**Our ref:** NO/2019/111448/01-L01  
**Your ref:** 3/2019/0007  
**Date:** 31 January 2019

**EXTENSION TO EXISTING WORKSHOP AND CREATION OF PARKING AREA.  
JAMES ALPE LIMITED LINCOLN WAY, CLITHEROE, LANCASHIRE, BB7 1QD.**

PROPOSED PLANS AND ELEVATIONS

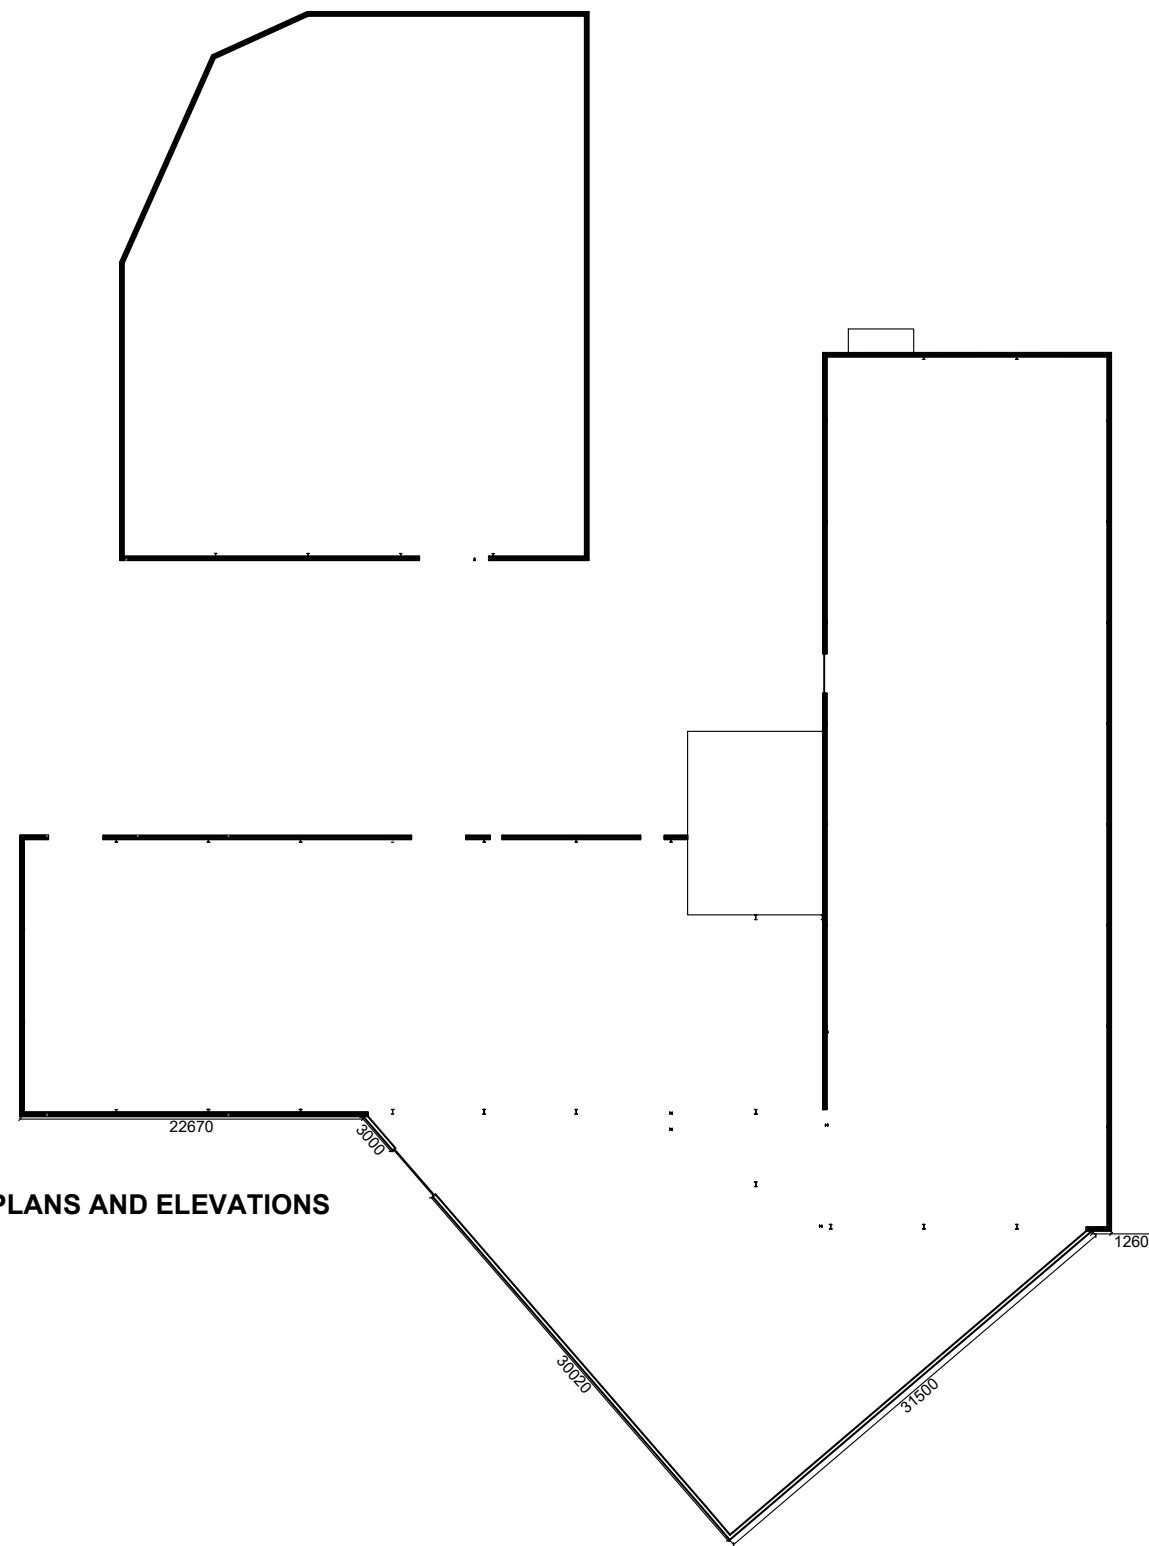
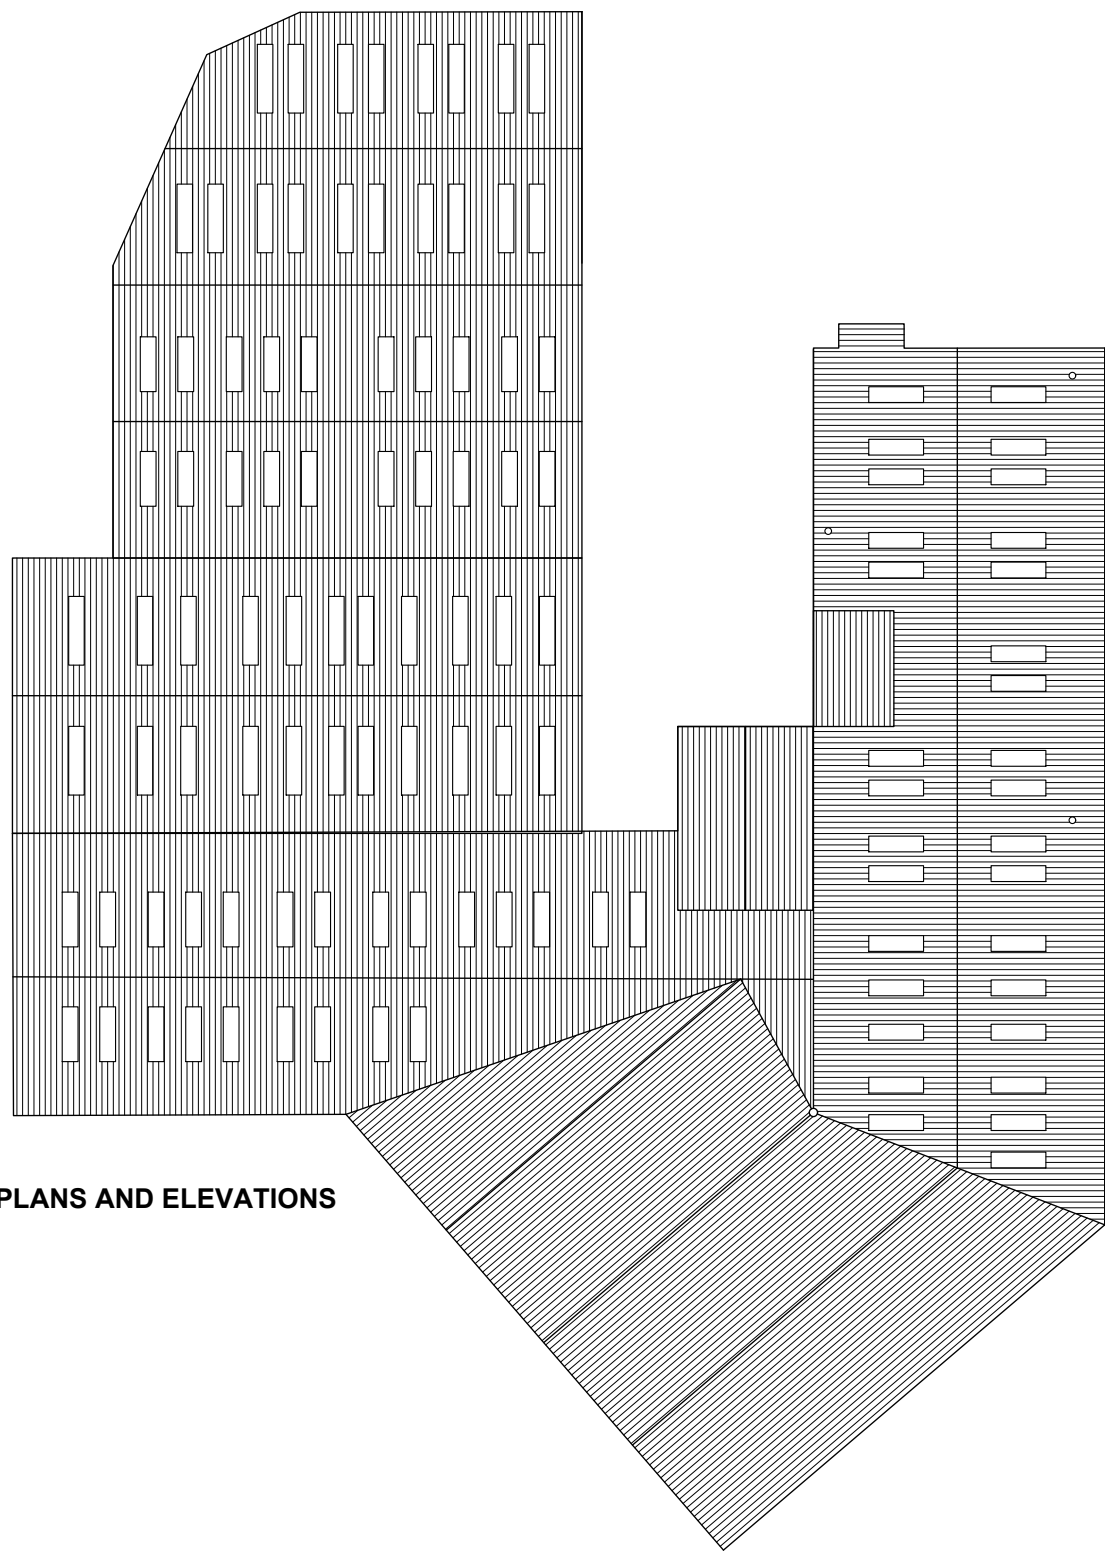
We object to this application as it involves building works within 8 metres of a Main River watercourse, in an area which is within a floodplain. As submitted, it is unlikely that we would grant a flood risk activity permit for this application.

- The proposed development would restrict essential maintenance and emergency access to the watercourse. The permanent retention of a continuous unobstructed area is an essential requirement for future maintenance and/or improvement works.
- The proposed development would obstruct flood flows, thereby increasing the risk of flooding to surrounding areas.
- The underside of the proposed bridge would need to be at least 600mm above the 1 in 100 year flood level, which would be unachievable.
